**From:**  
**Sent:** 31 August 2026 15:57  
**To:** DC Admin; Ellie Thornhill  
**Cc:**  
**Subject:** Objections on Application 2026/62/91763/E

Application number: **2026/62/91763/E**

What is the application for?: **Erection of 40 residential dwellings and associated works**

Address of the site or building: **Land off Barnsley Road, Denby Dale, Huddersfield, HD8**

PUBLIC OPEN SPACE PLAN - BARNESLEY ROAD, DENBY DALE

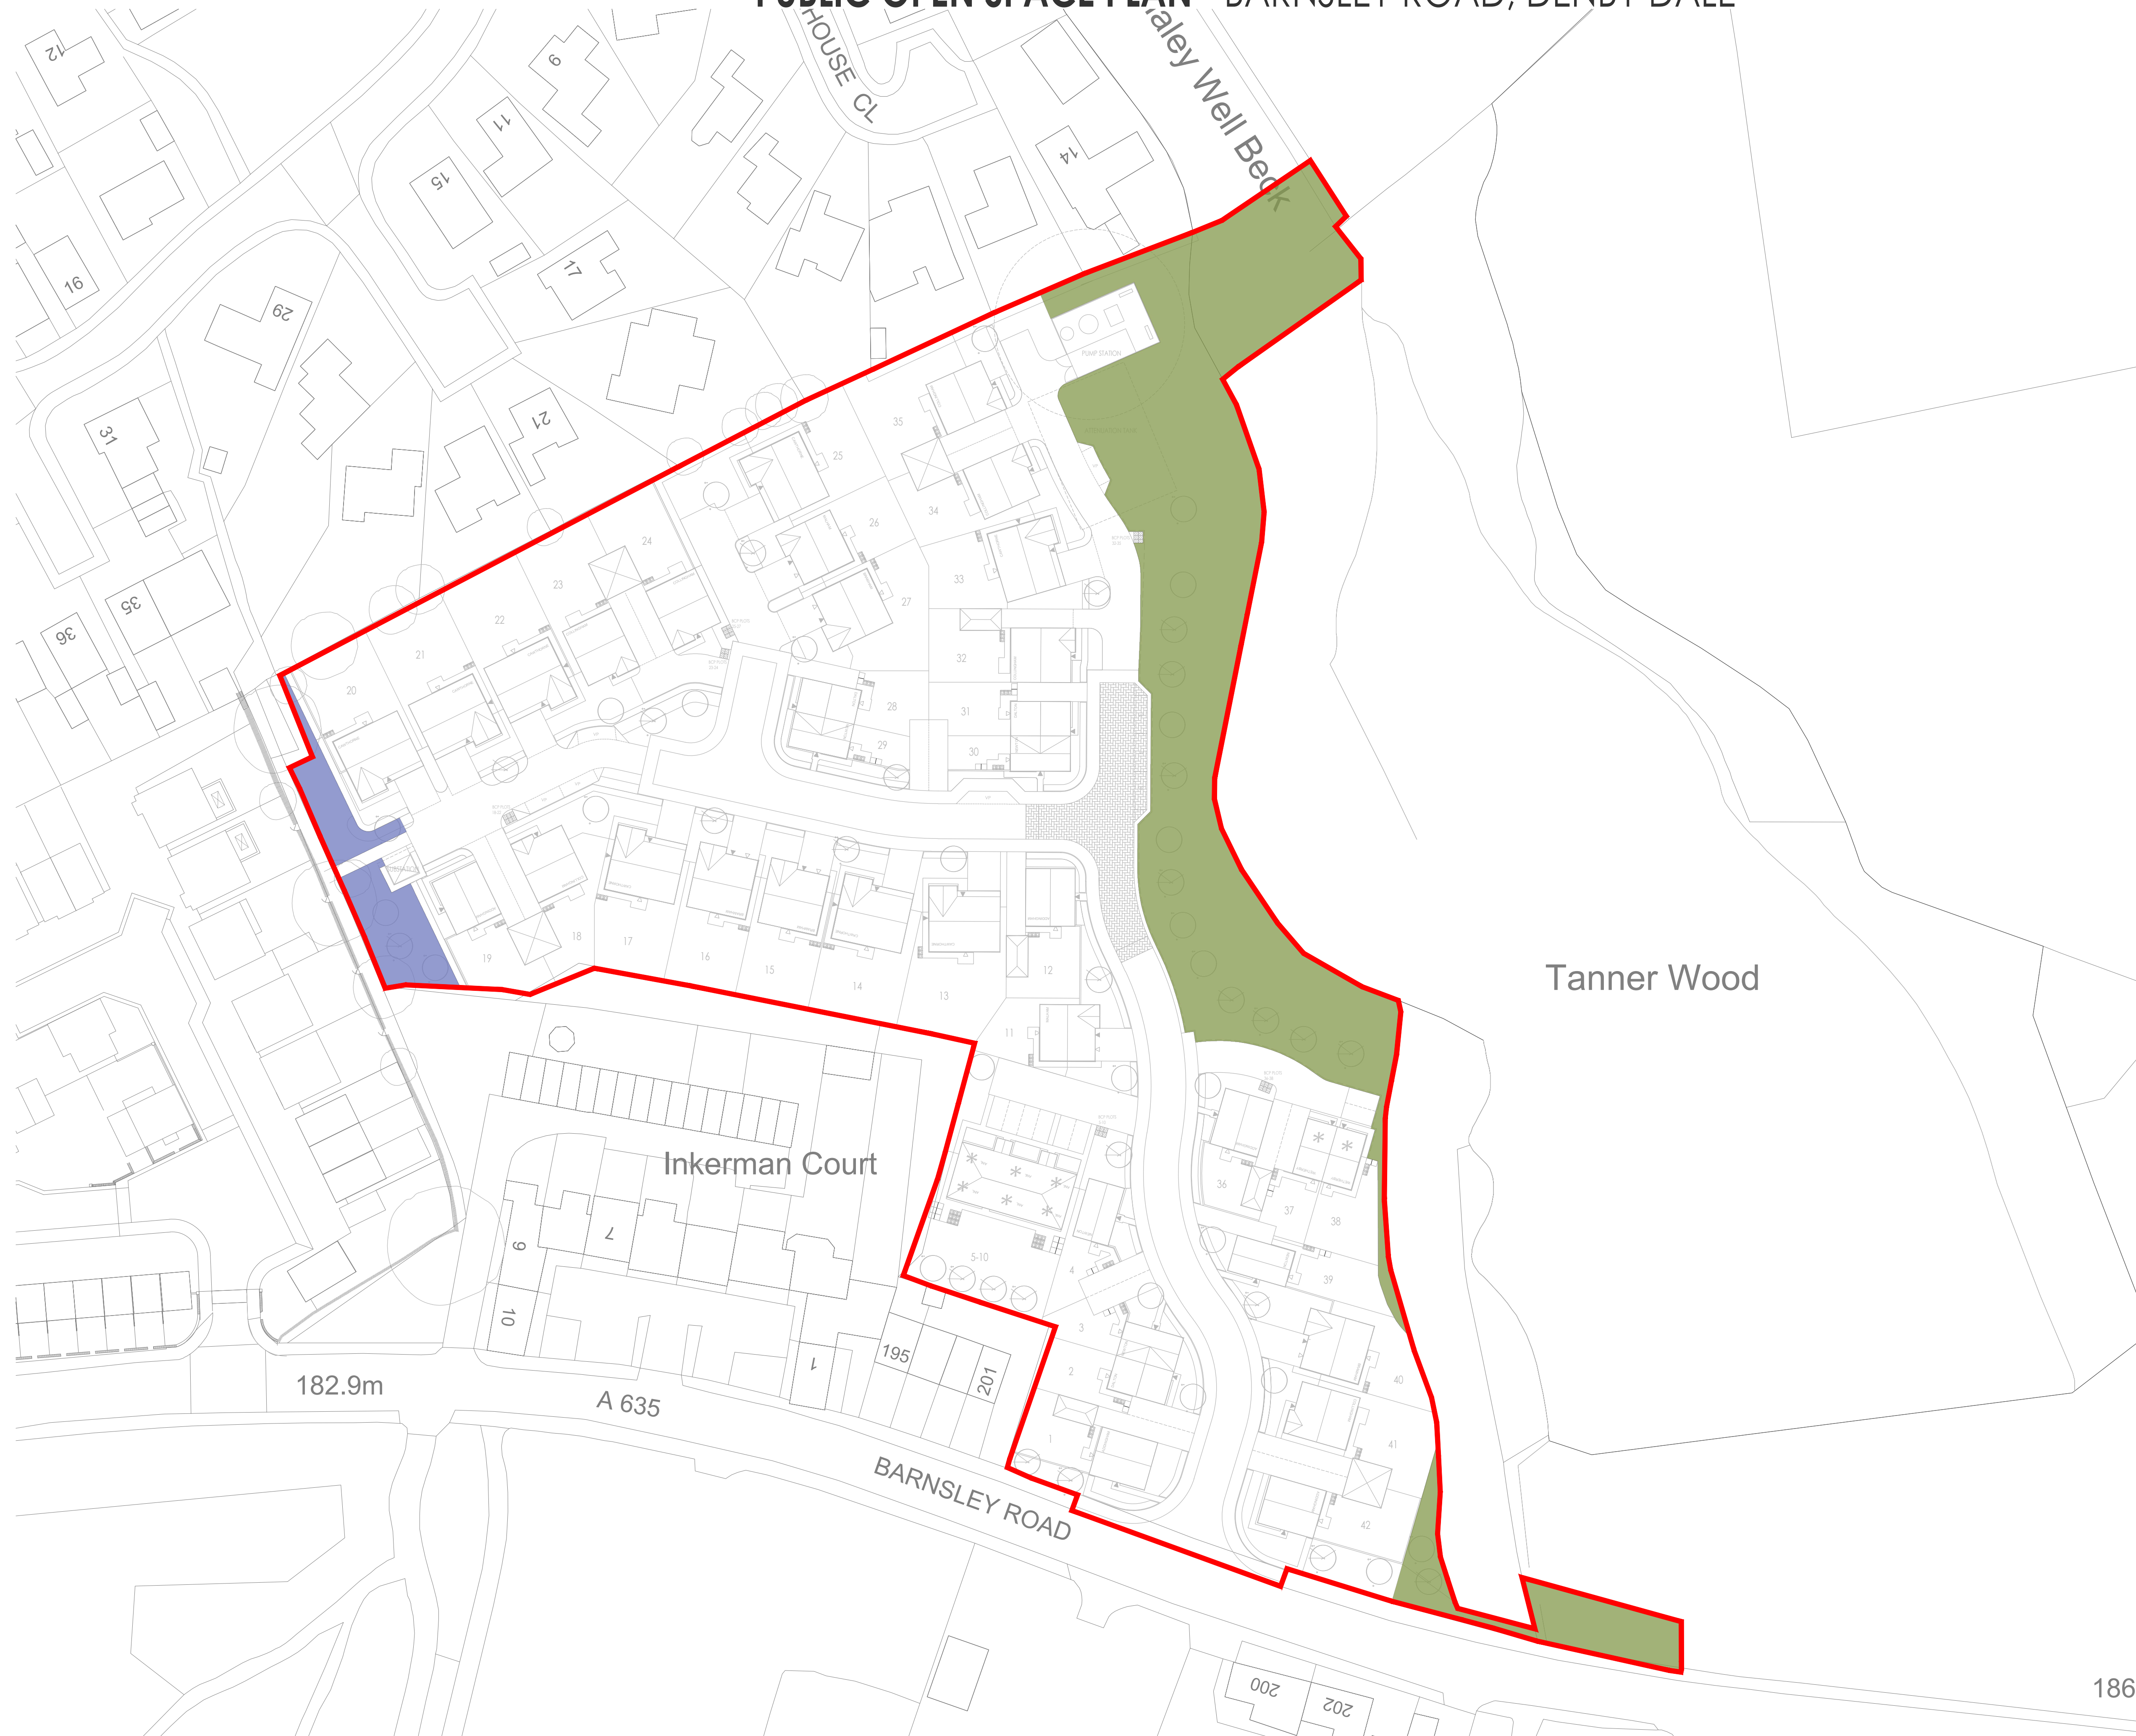
- The attenuation tank and pump station are incorrectly located on the landscape master plan (*Proposed Landscaping Layout [id 1150837] - DR-8717-01 Landscape Masterplan Rev D*) compared to the other plans, for example the *Proposed Landscaping Layout [id 1152117] - Plan - 2530-SI-08A - Public Open Space Plan* and others.

SITE LAYOUT PLAN - 2530-SI-02H
BARNESLEY ROAD, DENBY DALE
NEWETT HOMES
SCALE:1:500@A1 - AUGUST 2025

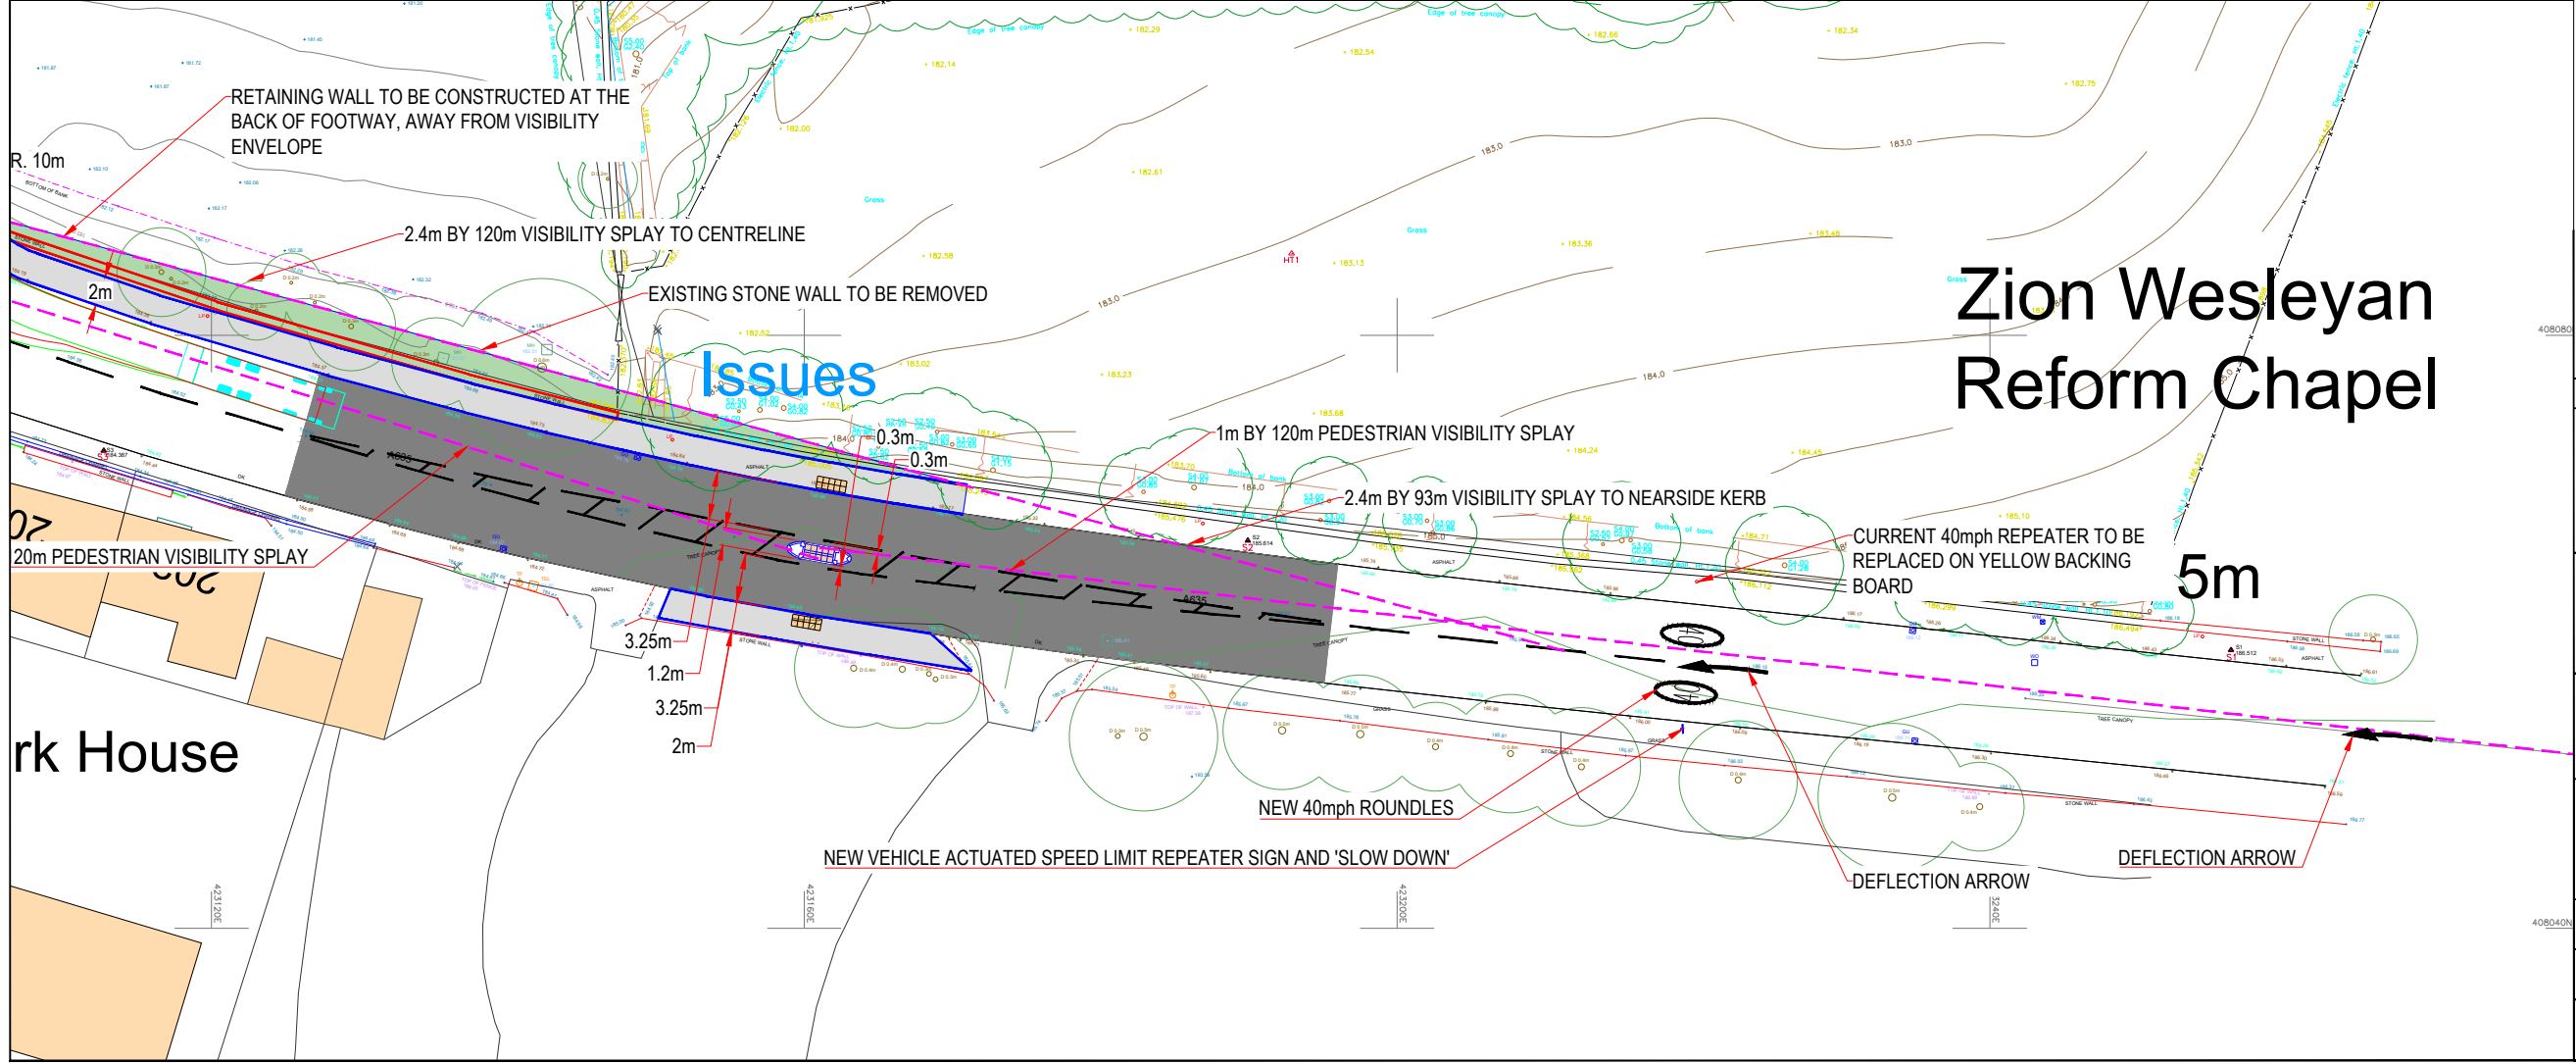
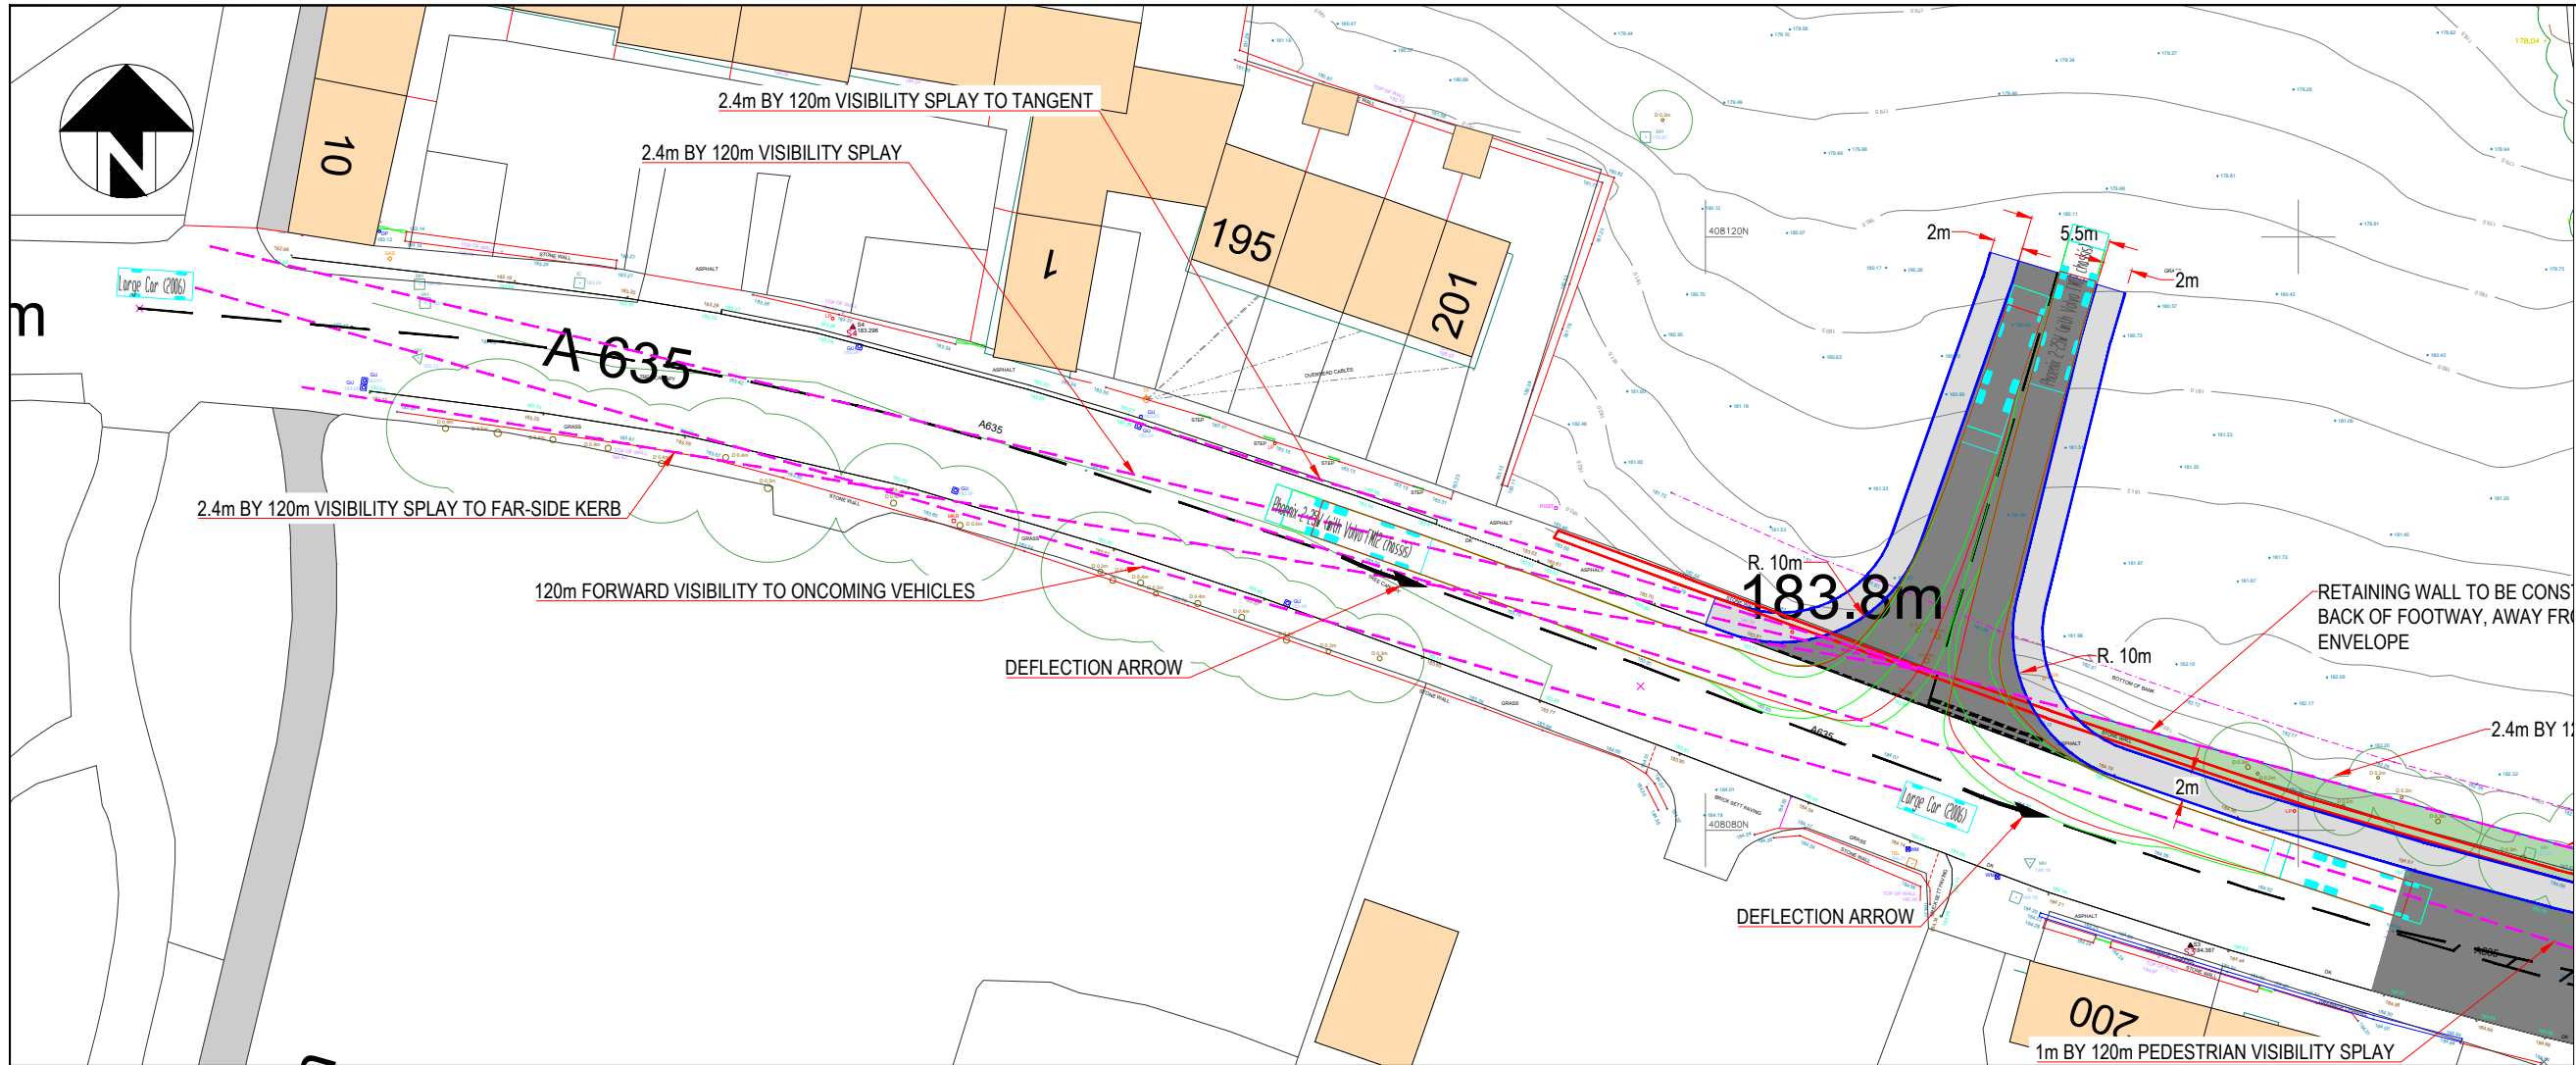
- Plots 39 and 40 should be oriented to be looking at the woods, it would improve their outlook and assist in reducing overlooking of 10, 12 & 14 Broomhouse Close. It would also meet the 21-metre rule.
